Rezoning Transportation Analysis

Petition Number: 2023-039

Date	Description
7-26-23	First Review (IW)
11-27-23	Second Review (DR)

SECTION C - PUBLIC STREET (NETWORK)
2+ AVENUE, BUFFERED/SEPARATED BIKE LANES
SCALE: 1/4\"/>

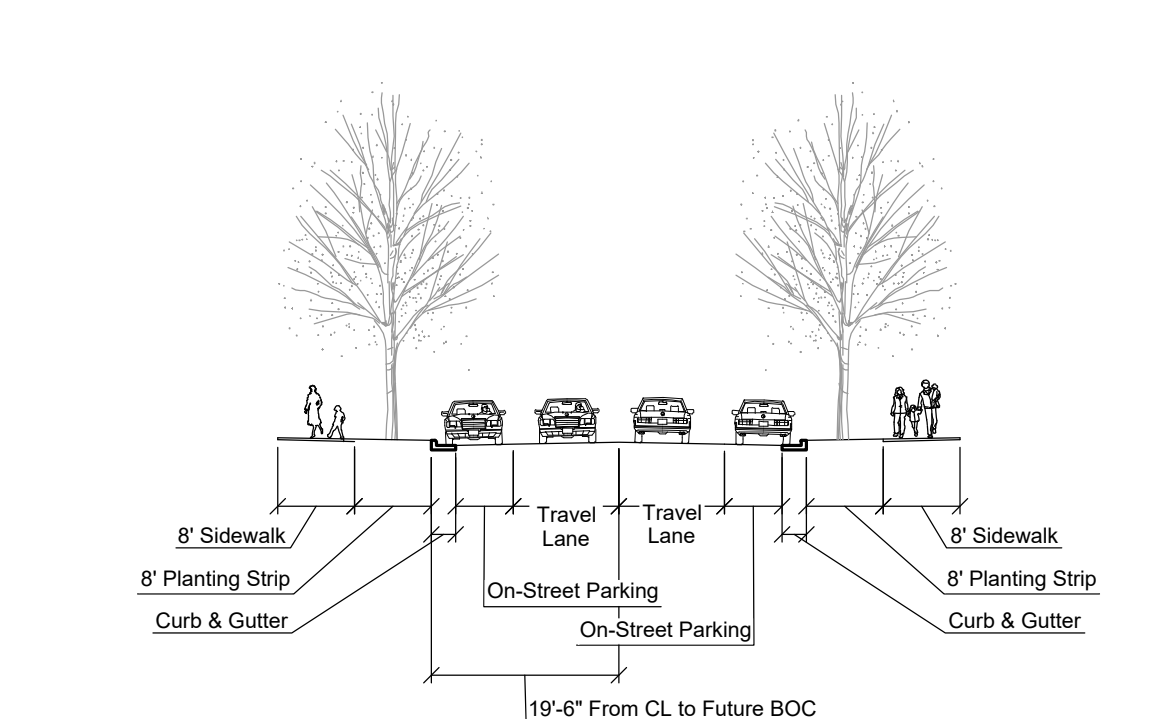
Clarifying comment 11.27.23: ROW dedication for Old Providence should be 43' based on the 8' sidewalk on Old Providence Road instead of the 6' sidewalk dimension shown on Section C.

New Comment 11.27.23: Section C public street network sidewalk width does not match the conditional note. Revise Section C to have an 8' sidewalk like the conditional notes for the Old Providence Road section.
